16 July 2018

# Sydney Football Stadium Replacement Concept proposal and Stage 1 Demolition (SSD 9249)

The City of Sydney *objects* to the concept development application for redevelopment of the Sydney Football Stadium and concurrent Stage 1 works including demolition of the existing stadium.

Driver Avenue Terraces Section

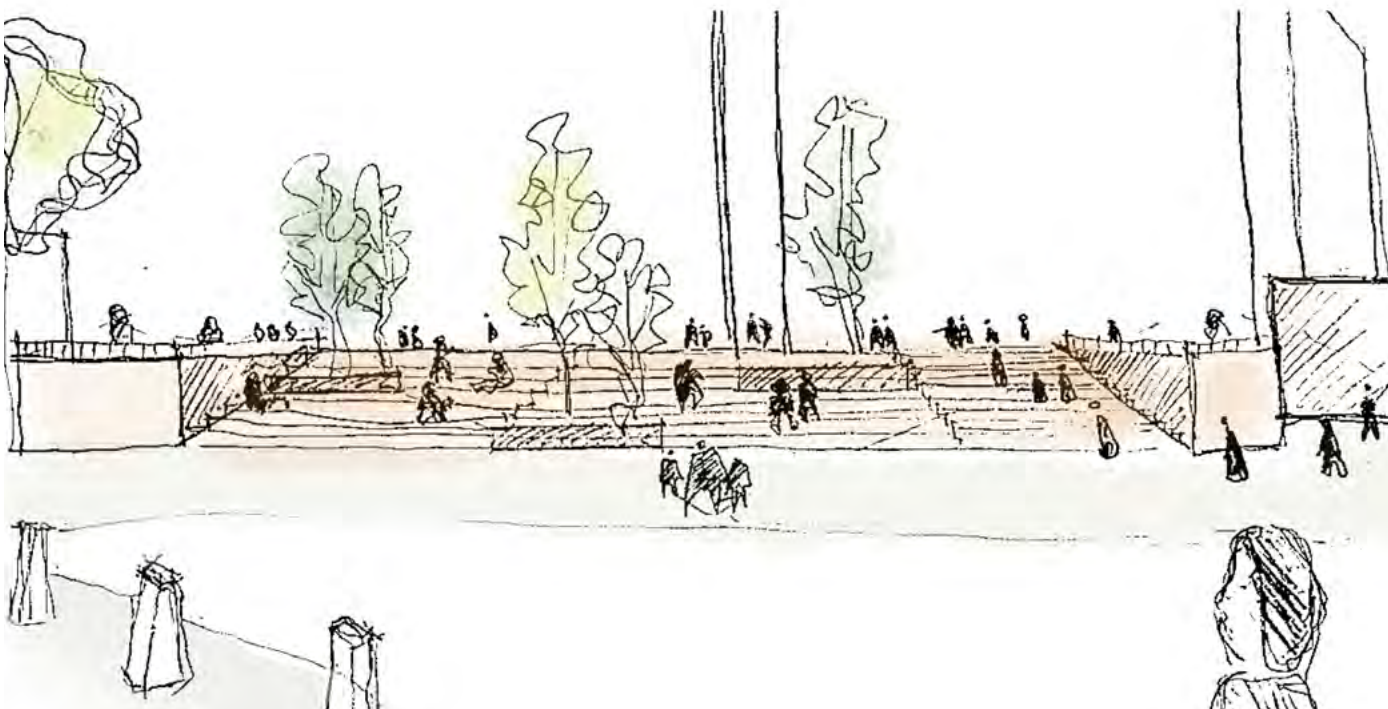
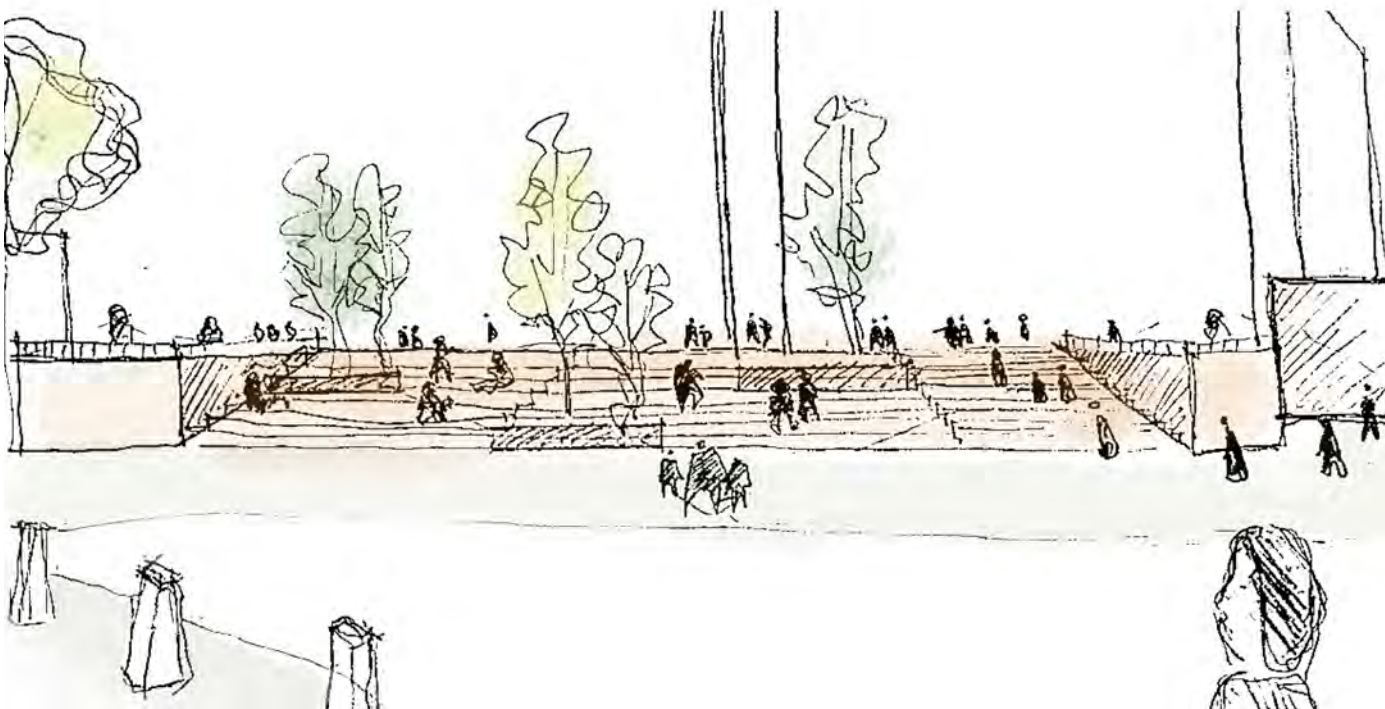
The proposed stairs to Driver Avenue present a safety hazard for patrons entering and leaving the stadium. The movement on stairways particularly the downward movement poses a potential risk to crowds both in normal circumstances, such as at the end of an event or in an emergency.

Figure 32 Maximum proposed building envelope – site plan
Source: SJB

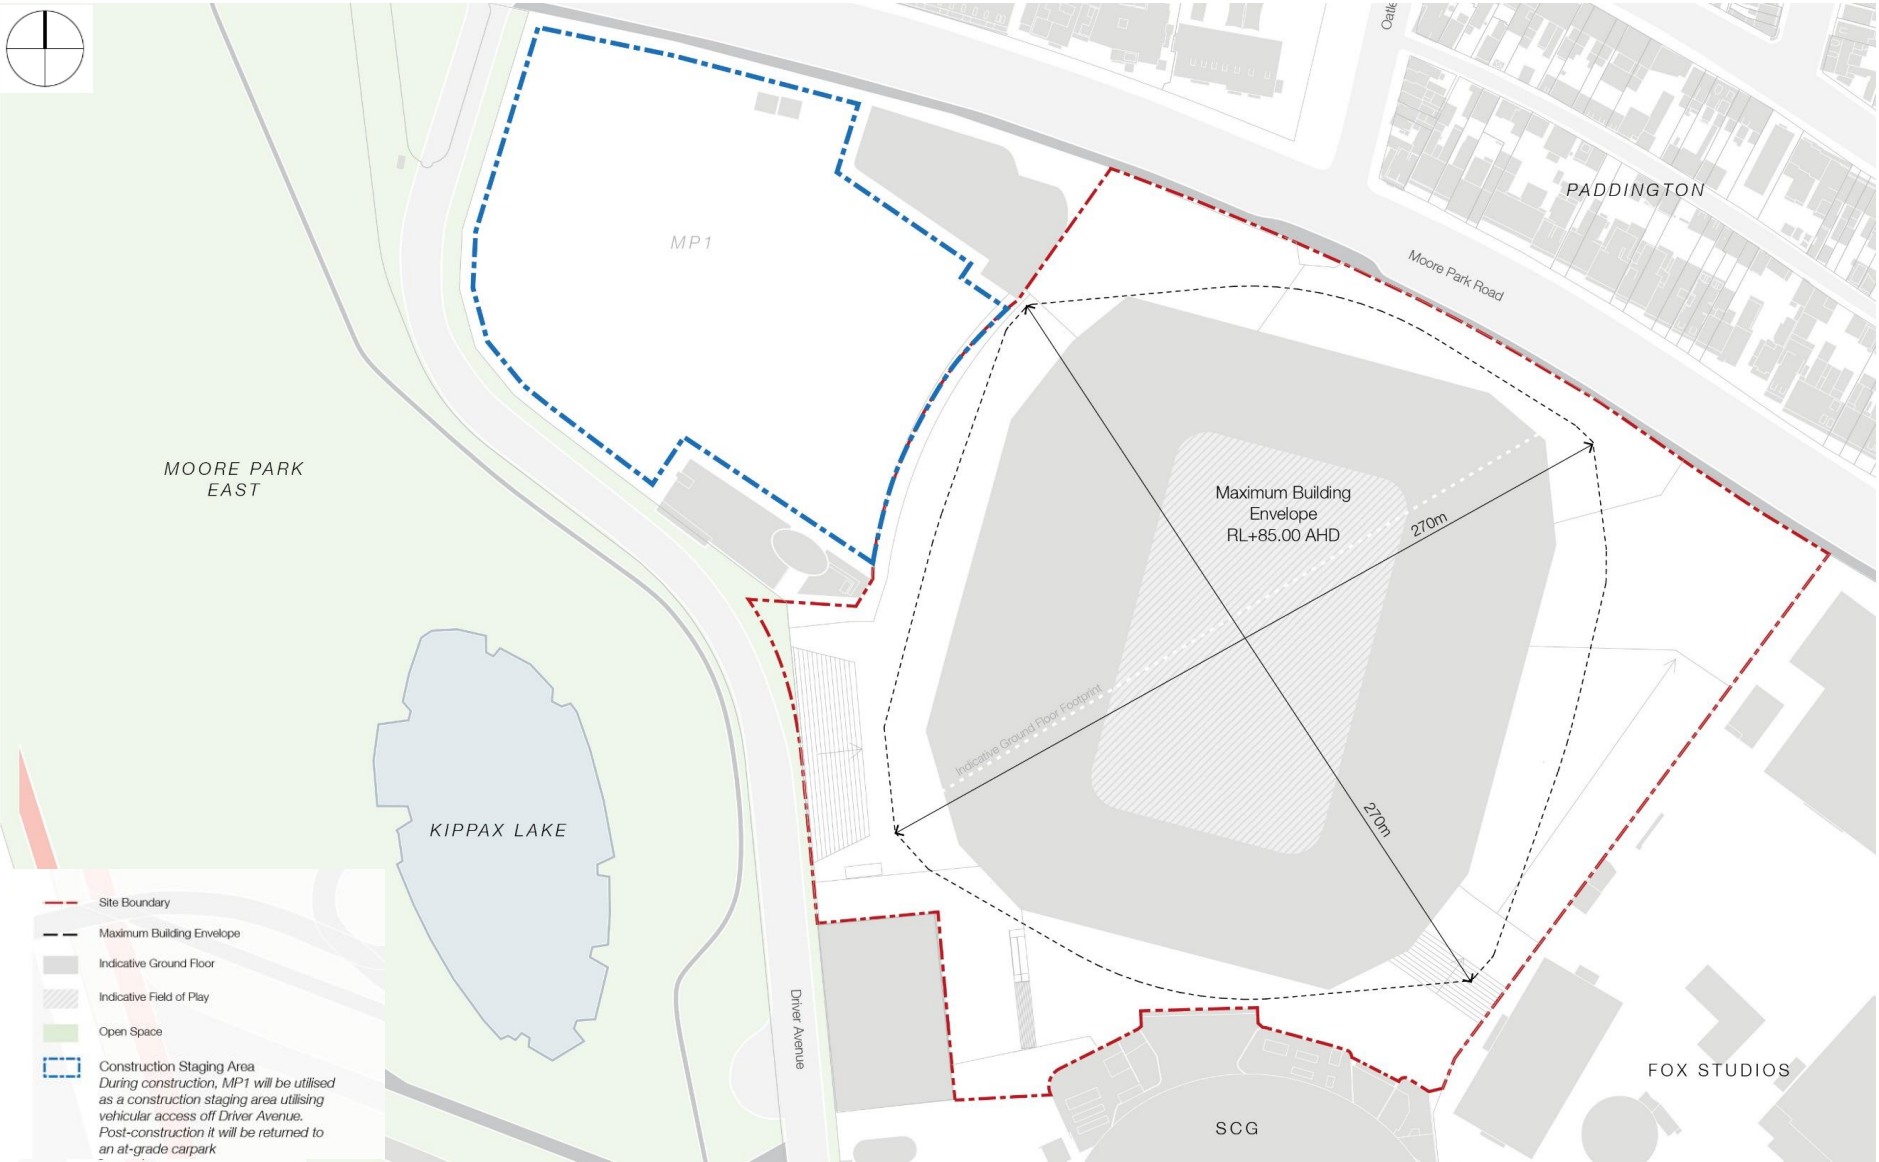
As illustrated in Figure 2, the proposed stadium footprint is too large for the site to contain the full range of enhancements; and compliance and security requirements generated by the proposed use.
